COLORADO
Department of Transportation
Region 2

April 22, 2019

SH 24
El Paso County

RE: Meadowlake Ranch Sketch Plan_EA17227_SKP184 - **REVISED addition of Hydraulics Review/Q/A Response**

EXISTING DRAINAGE PLAN

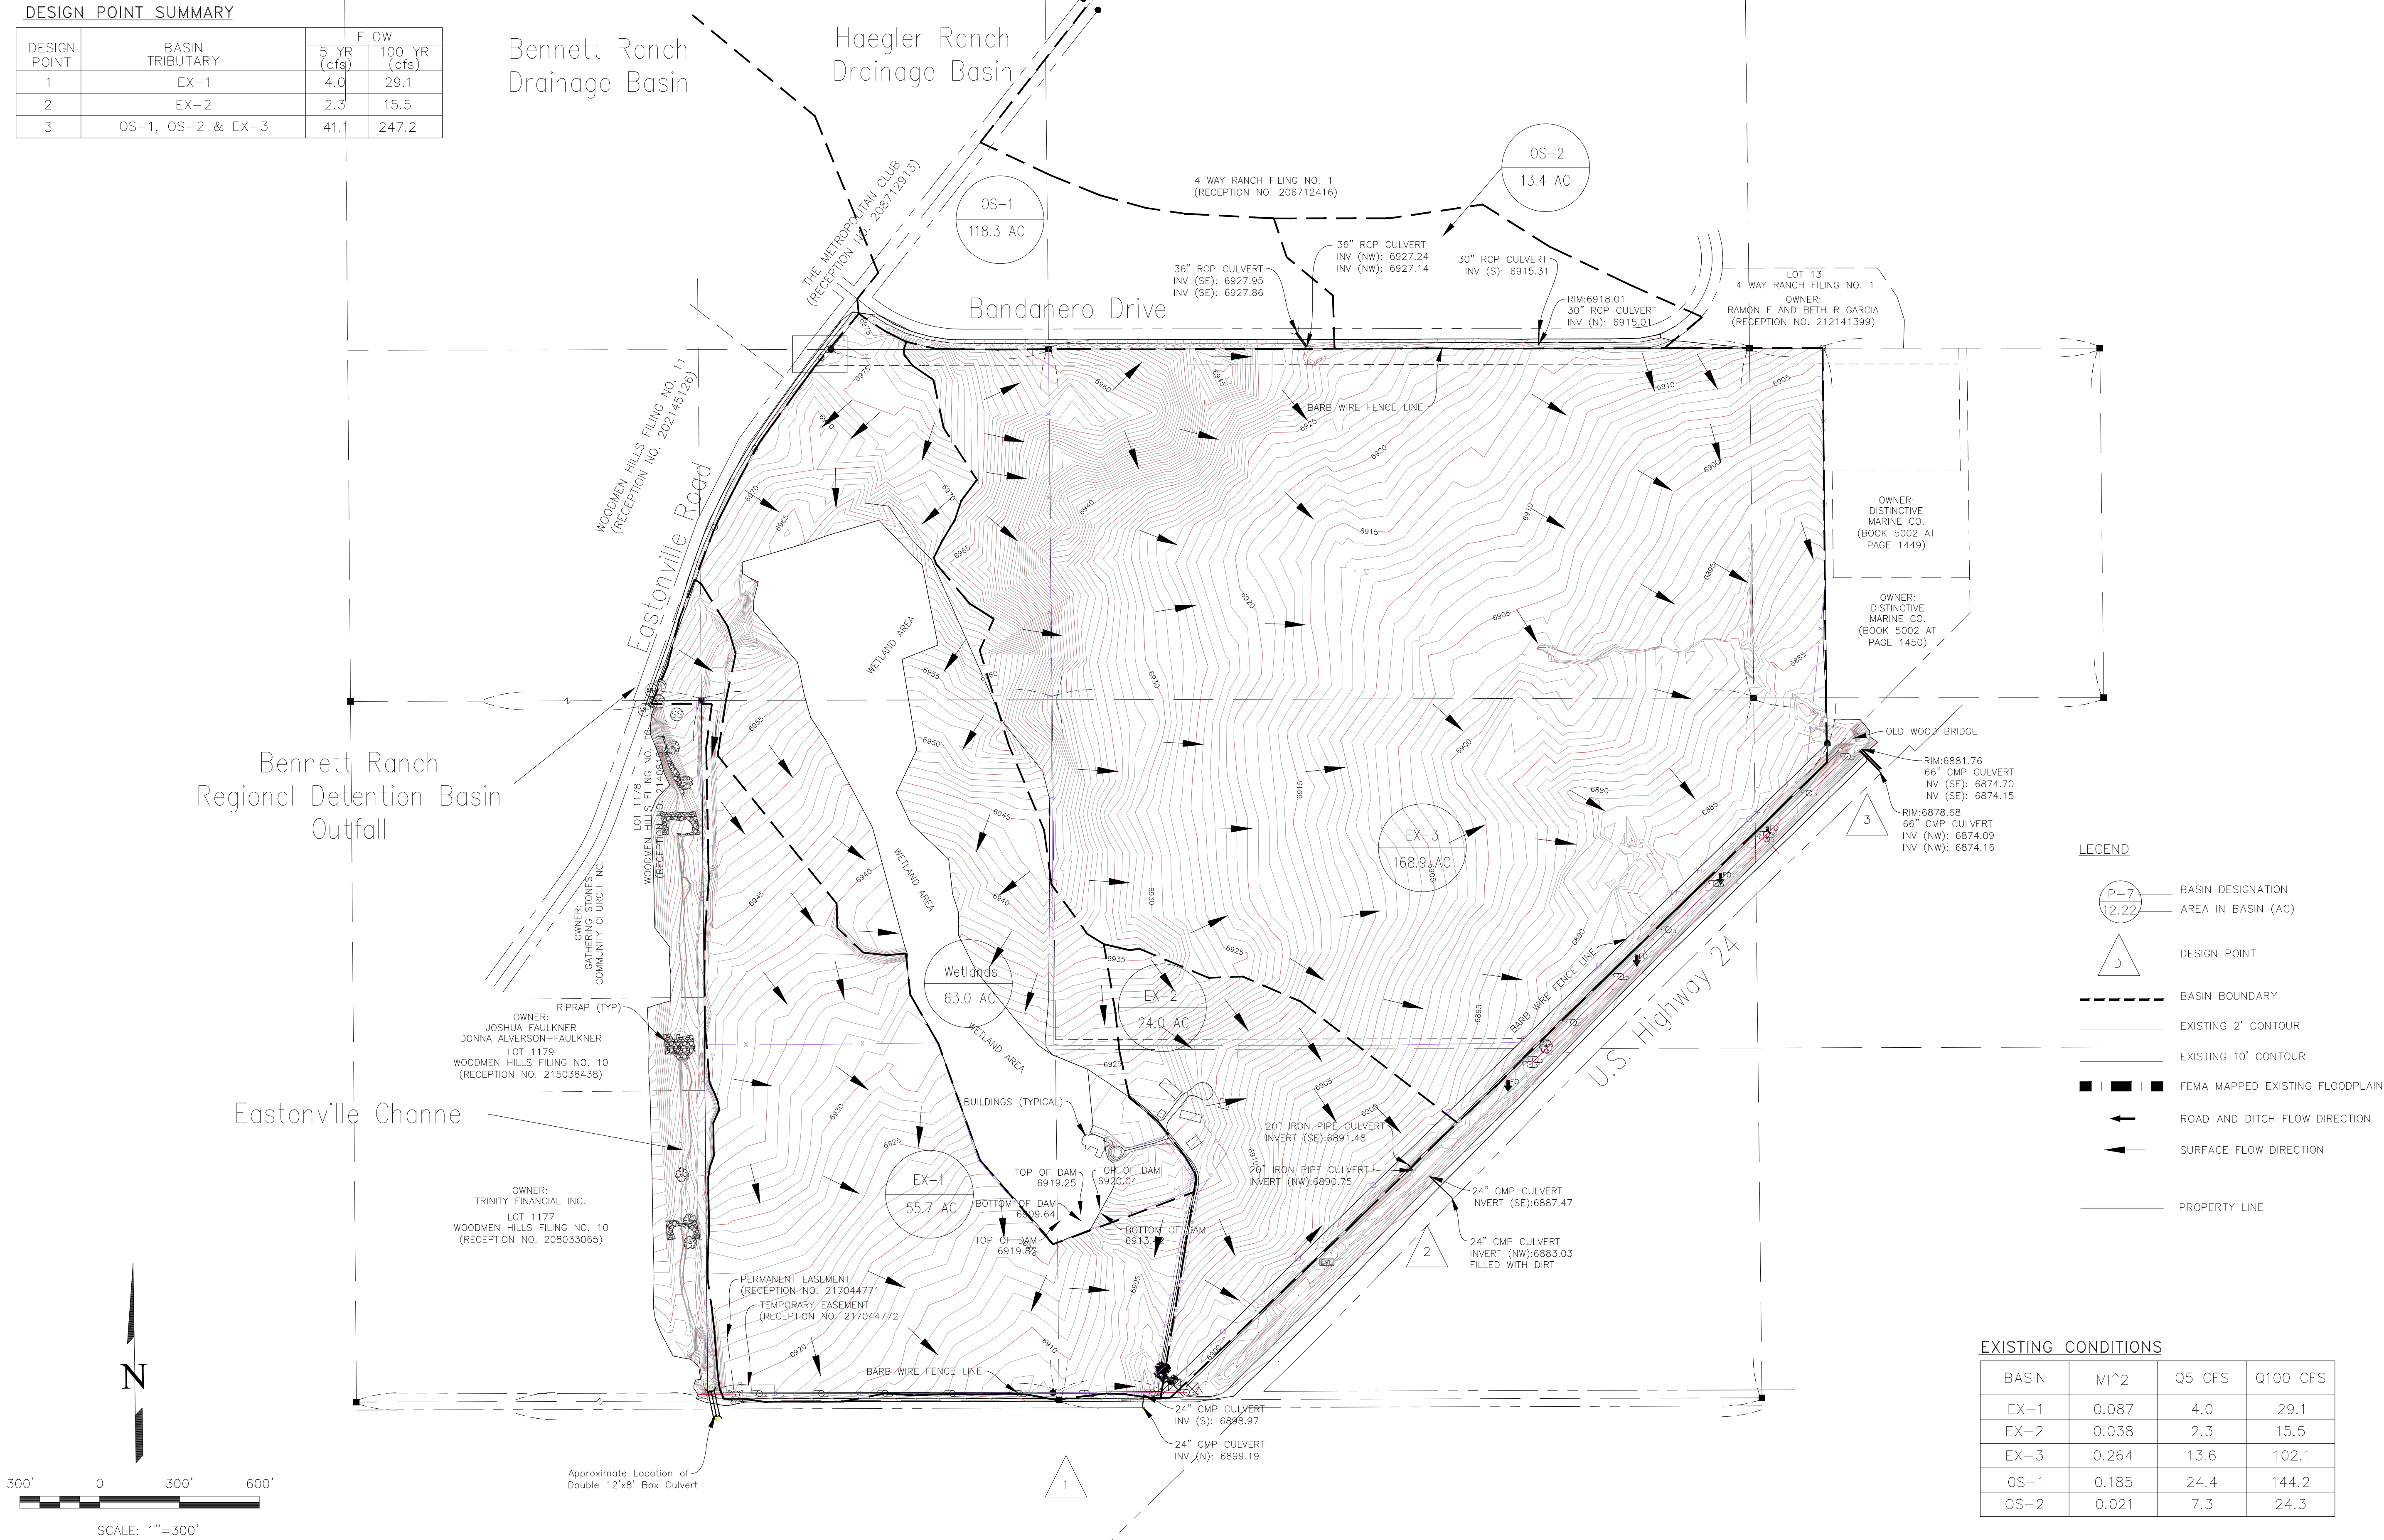
- b. Page 7 - Prove that this area doesn't contribute to downstream flows. Seems odd to eliminate basin area from analysis, especially since there is evidence of flows downstream of these wetland areas (natural swale, 24" CMP culvert under Judge Orr). Please show proof that this area can be removed from the hydrology.

- c. Page 8 - Tributary area and runoff discharge should include the 63 acre wetland basin. This will require improvements downstream. However, this outfall seems to have been analyzed already, and recorded with FEMA. See attached FIRM map, effective December 7, 2018. Please update discussion of this basin.

- b. **Response:** The flow that crosses under Judge Orr Road downstream of the wetlands/ponds area comes from the drainage basin west of the wetlands/ponds. The ponds do not have outlet structures and the berms are vegetated and stable. El Paso County requested additional analysis of this area and a revised MDDP was submitted in early March. Below is the discussion from the revised report.

- c. **Response:** As discussed above, the wetland/pond area will be retained in the proposed development and the berms regraded to attain the required runoff storage. The exact storage will depend on the development details, which are unknown at this time. The FIRM will be updated in the MDDP. The MDDP addresses the need for a detailed analysis of the Judge Orr Rd crossing, but such an analysis will be addressed in a future Drainage Report. The pertinent portion of the MDDP is included below.

- d. **April 22, 2019 - CDOT COMMENTS:** I've reviewed the responses and have no objection at this time. However, when this project moves forward to development, I would require some sort of dam breach analysis, to show potential impacts downstream, particularly the US 24 crossing. I don't feel comfortable allowing the removal of such a large drainage area without allowing for an emergency flow path.

PROPOSED CONDITIONS

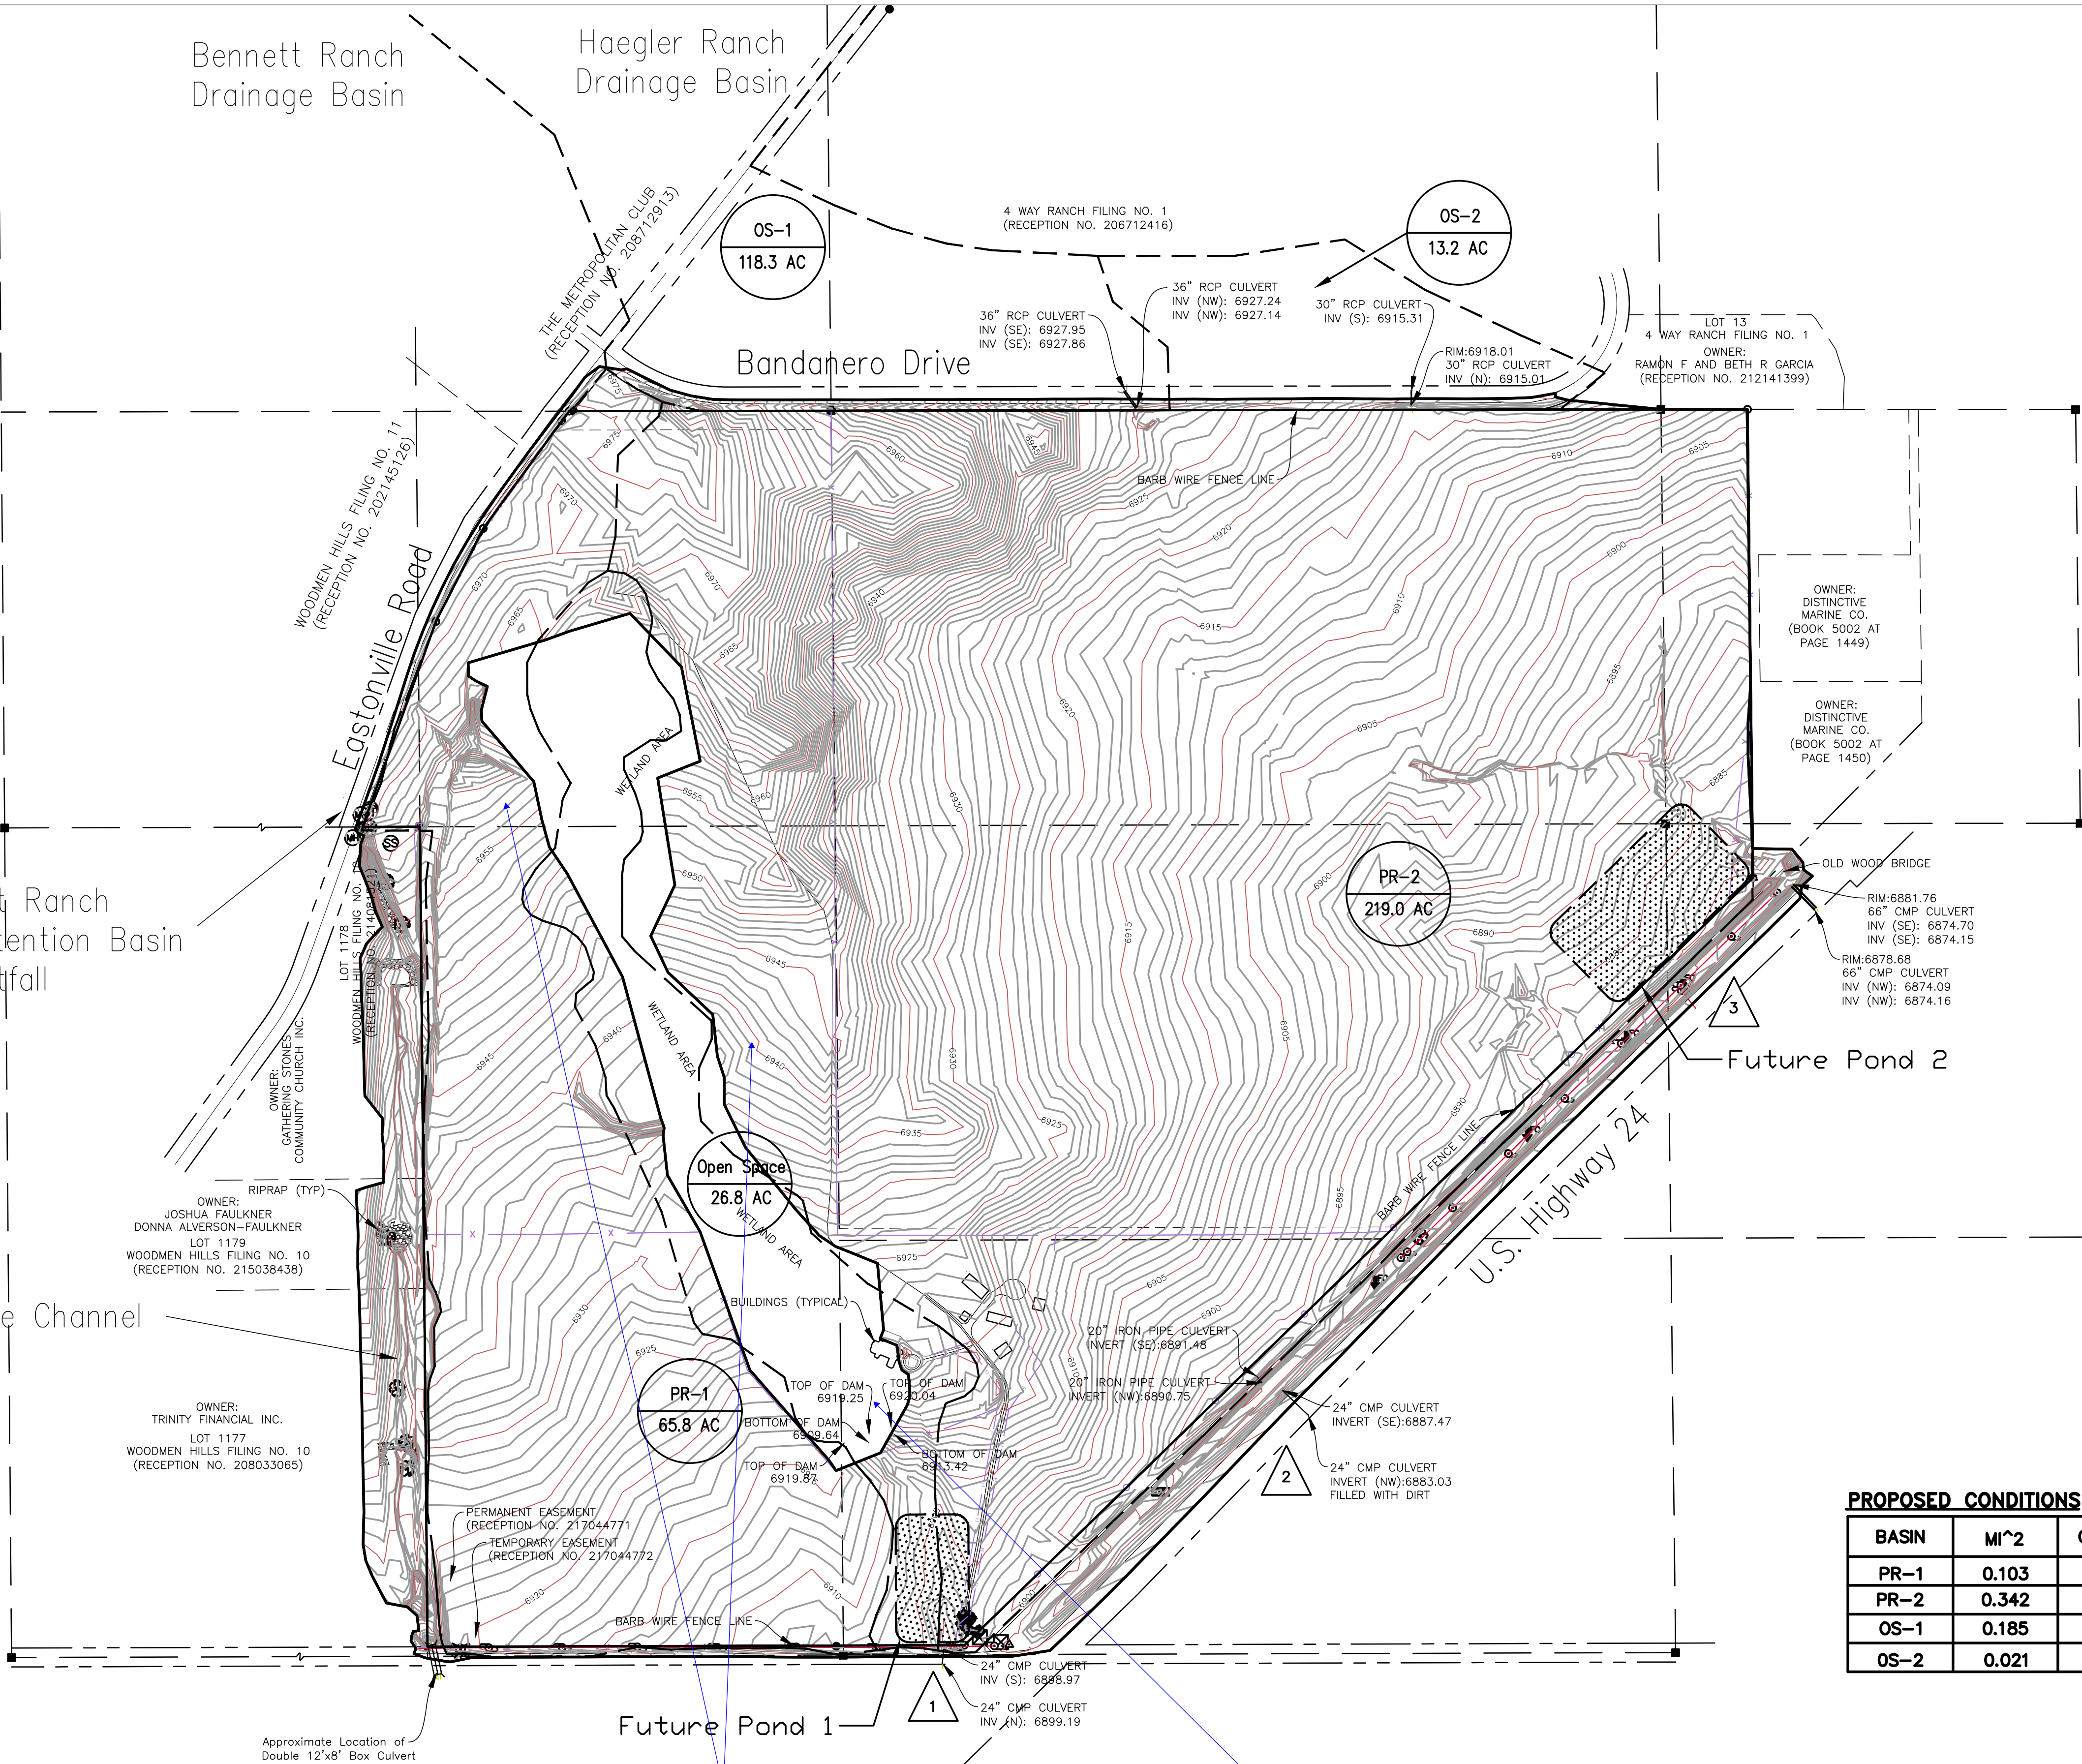
- a. Page 6 - "Therefore, existing runoff from the Meadowlake Ranch site does not contribute to Bennett Ranch Regional Detention Pond outflows and runoff from the proposed conditions will be routed away from that conveyance route as well". Does this change historic drainage patterns?

- a. **Response:** No, the historic drainage patterns flow to the southeast on the Meadowlake Ranch property away from the Bennett Ranch Regional Detention Pond outlet drainage way and will continue to do so. I will clarify that the proposed conditions will maintain historic drainage patterns.
